PLANNING AMENDMENT

PROPOSED HOME FOR THE BEREAVED

Description: Proposed home for the
elderly

Amendment: Alterations to front elevation; forming projecting bay
windows and central section to add relief to front

Drawing Title
ELEVATIONS AS PROPOSED

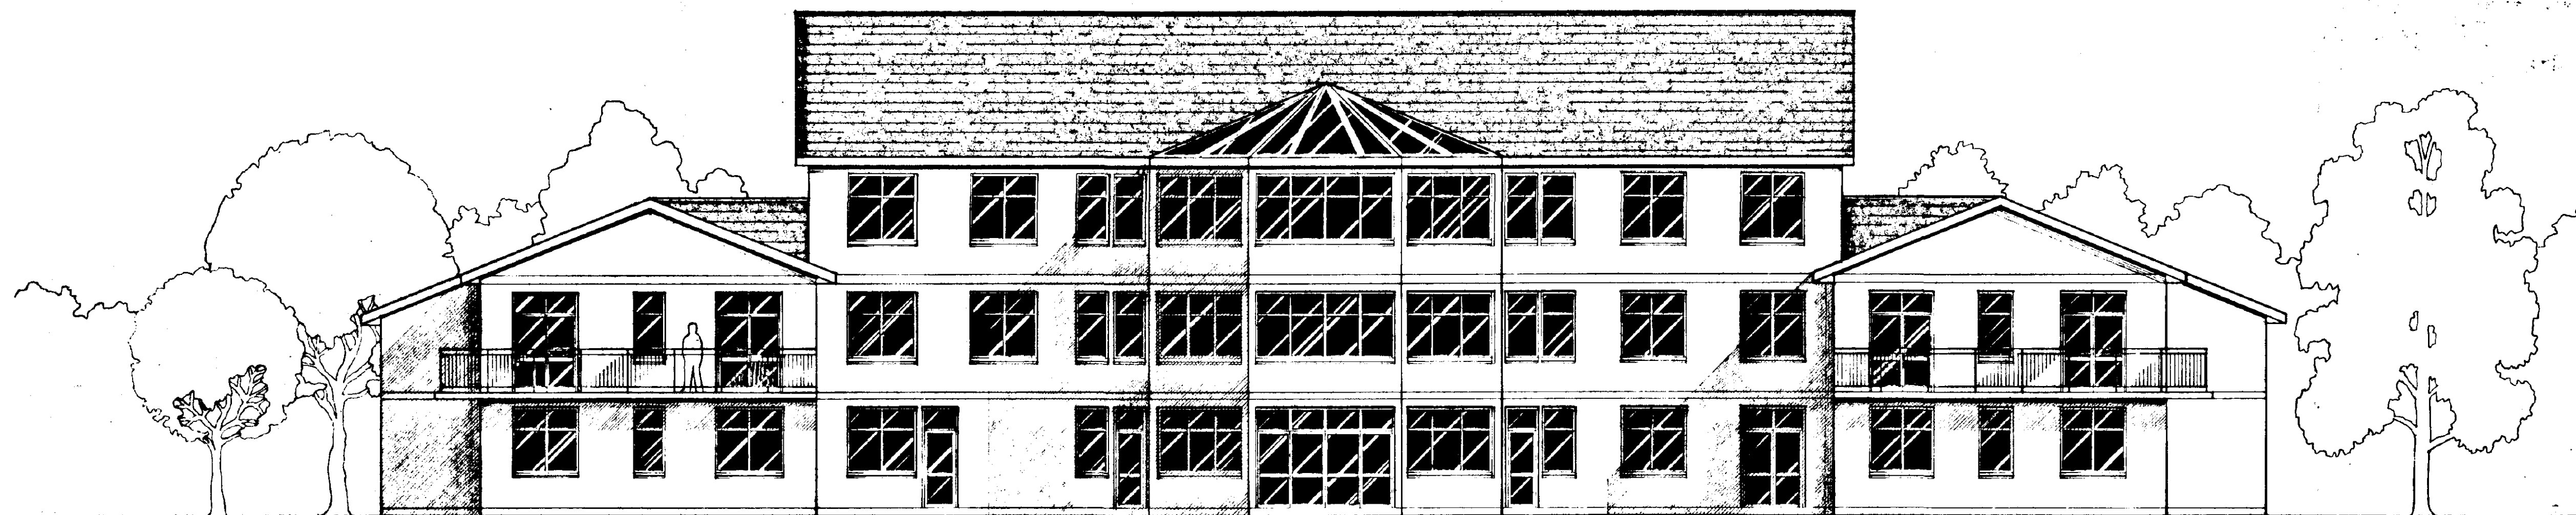
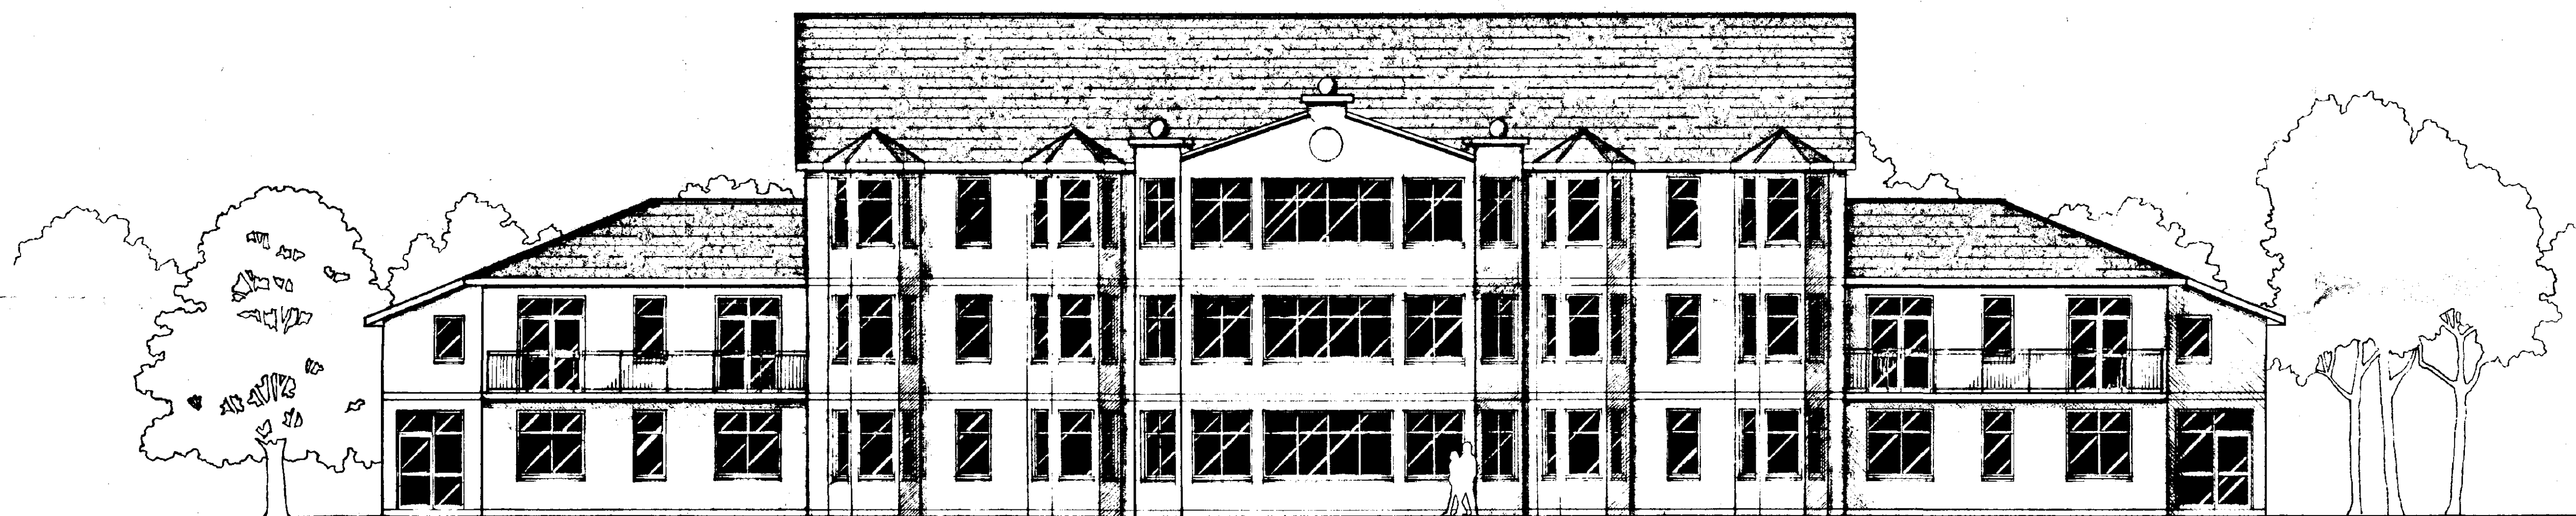
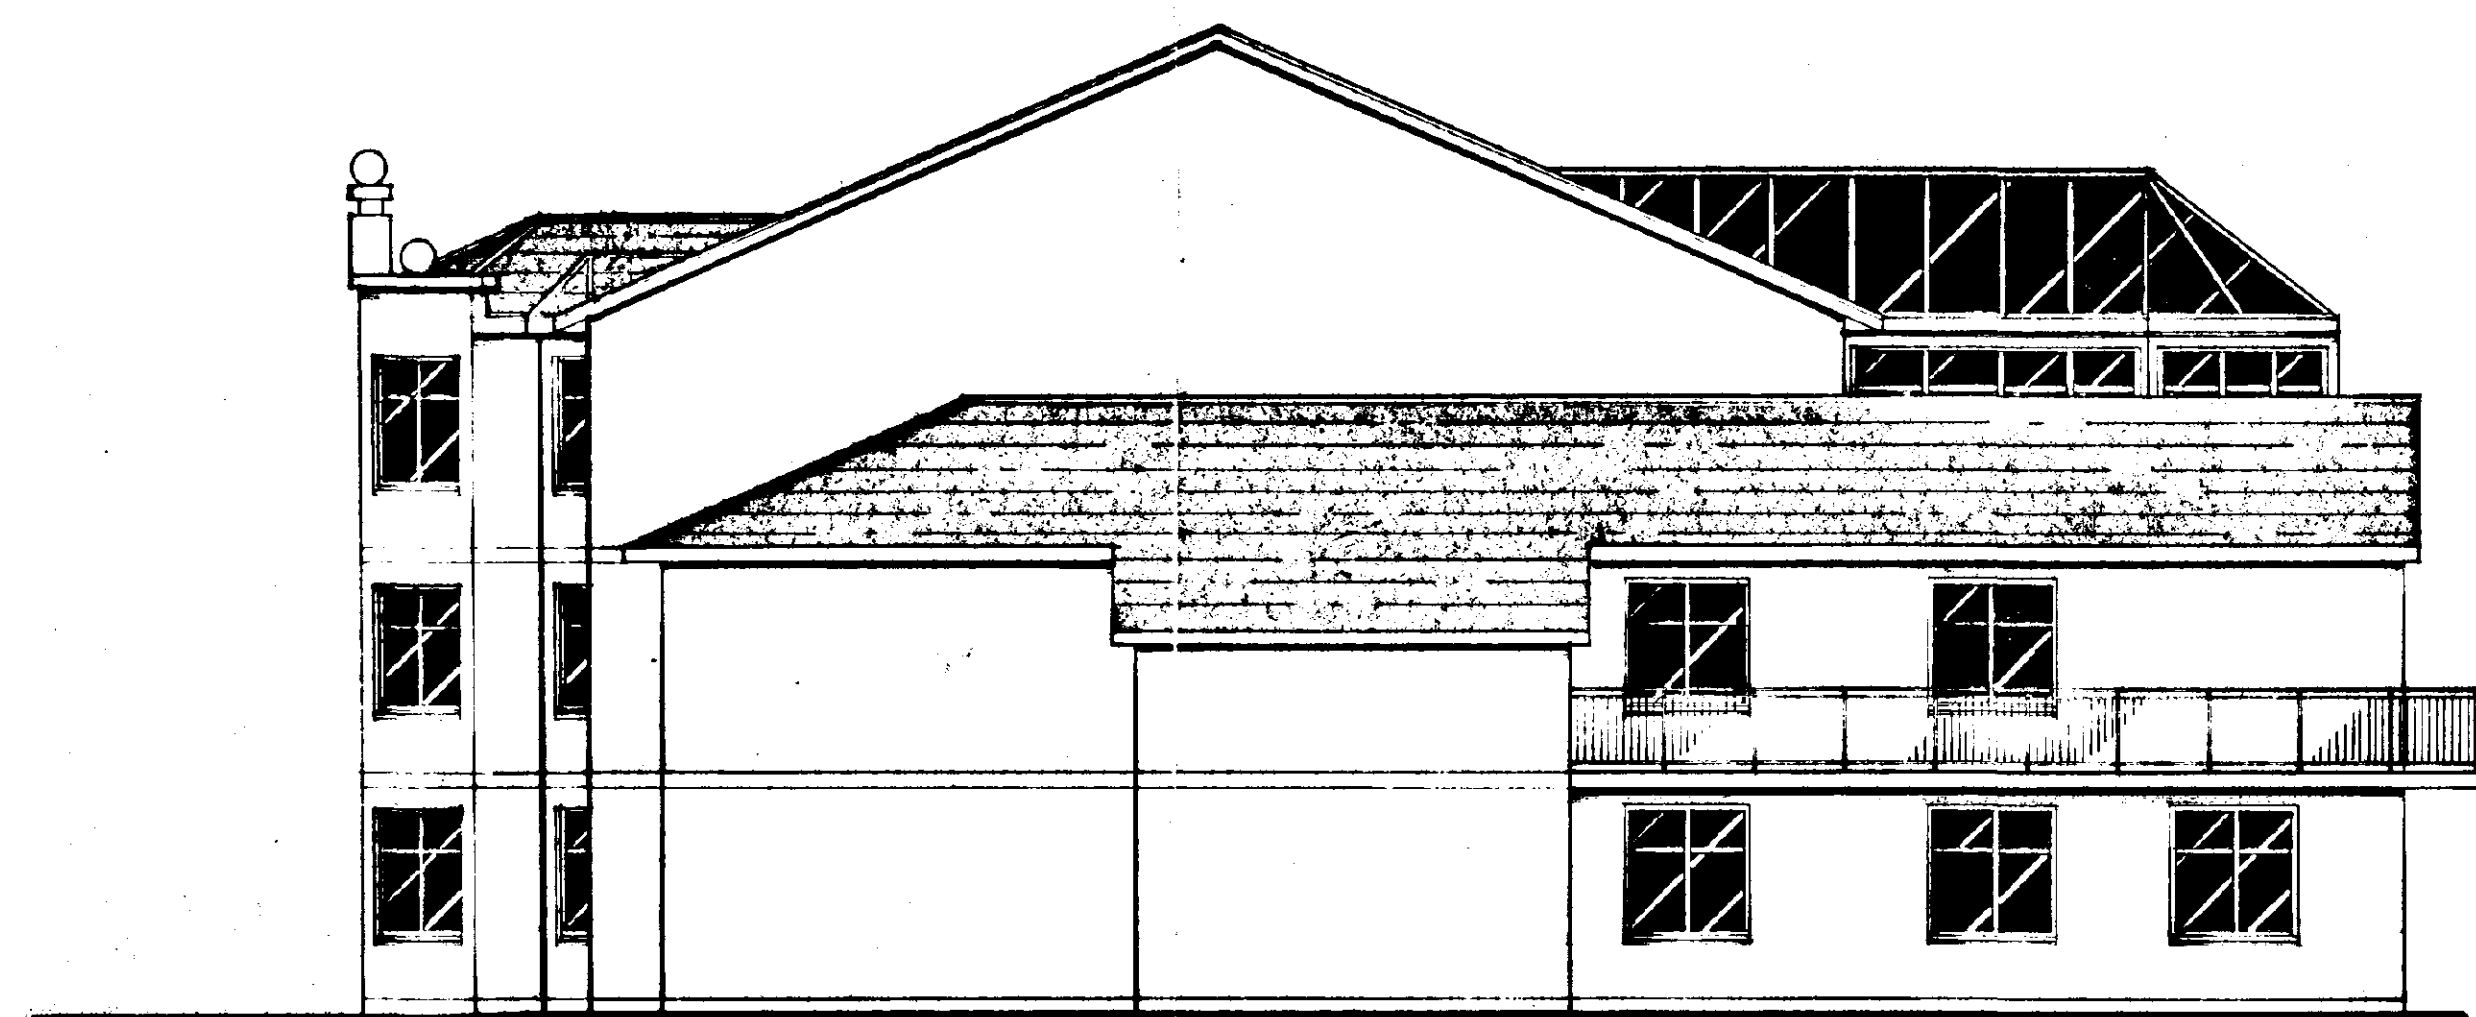
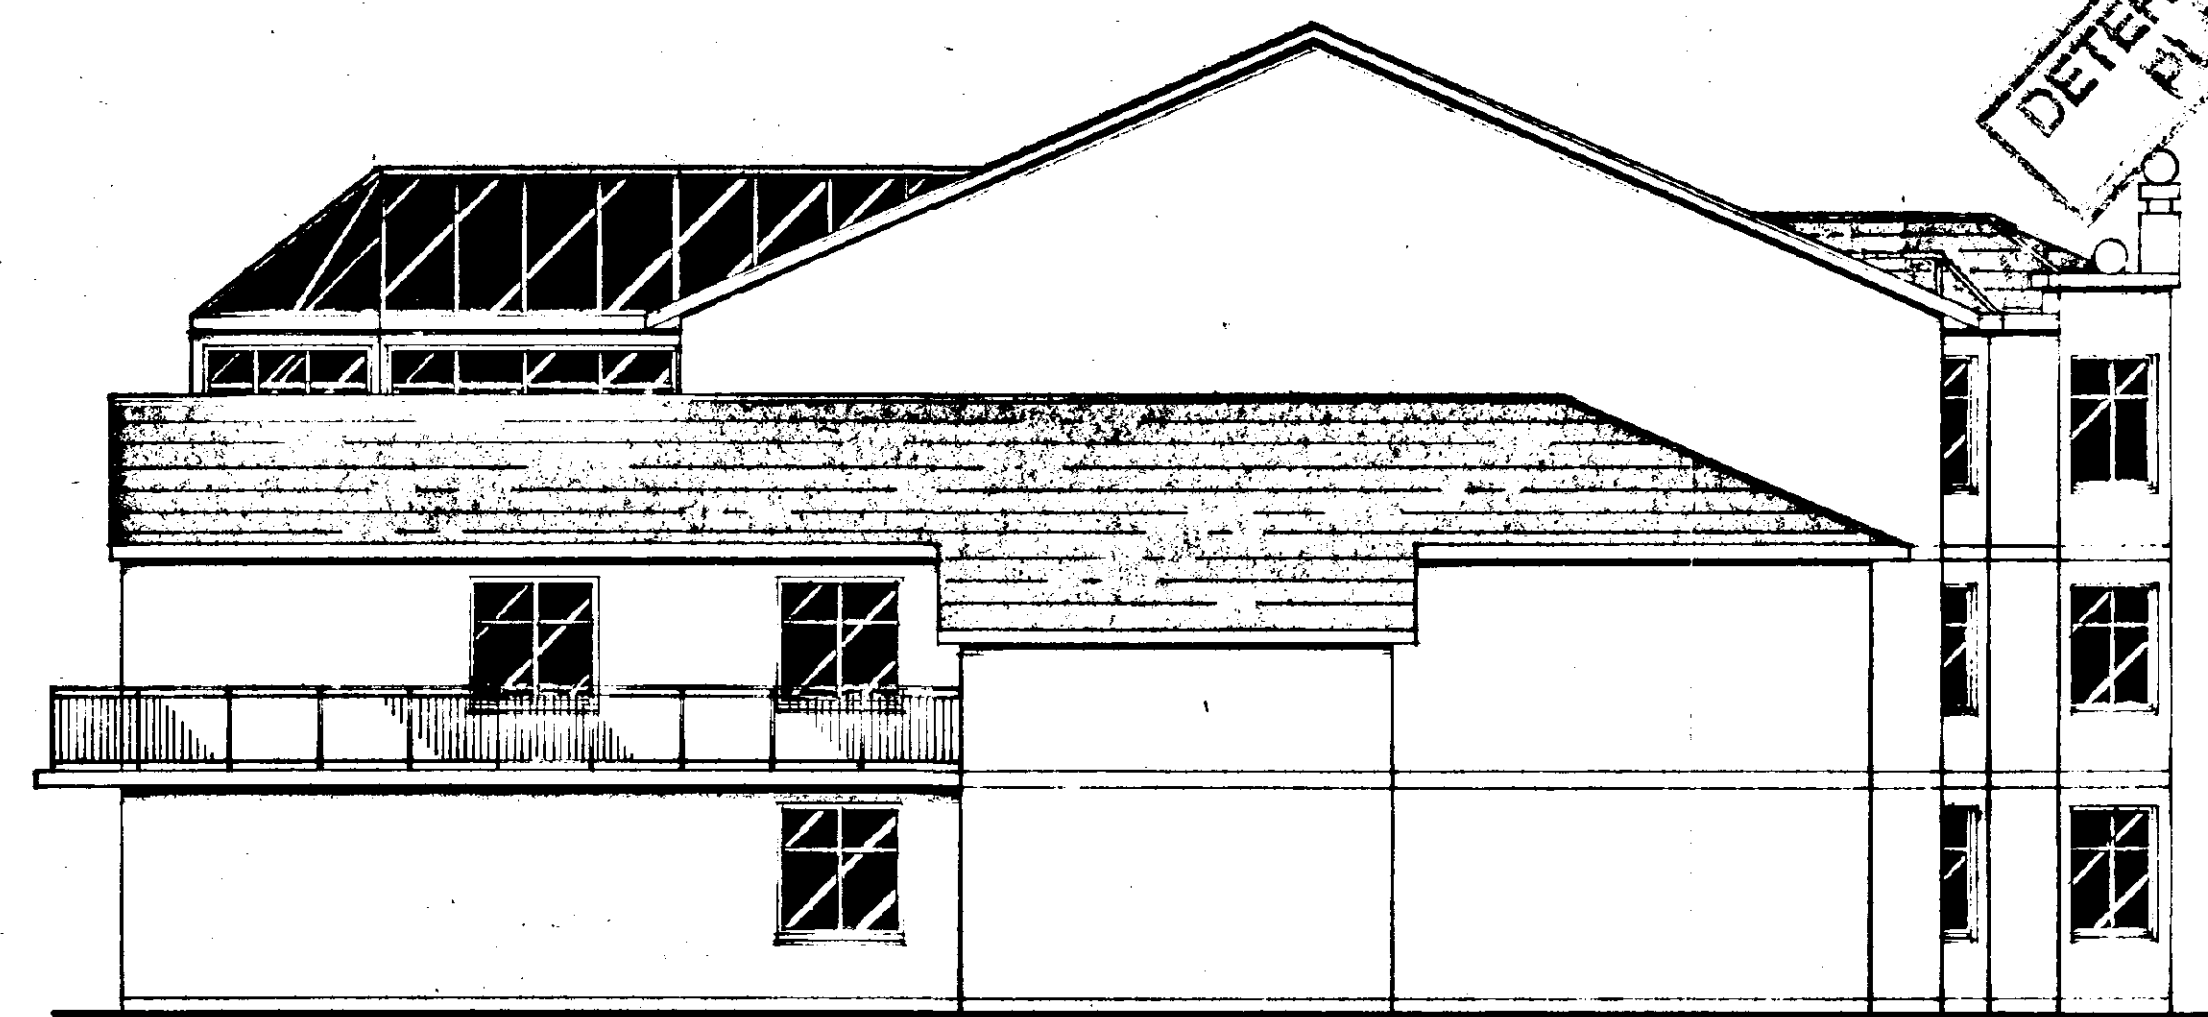
ALTERATIONS TO FRONT ELEVATION
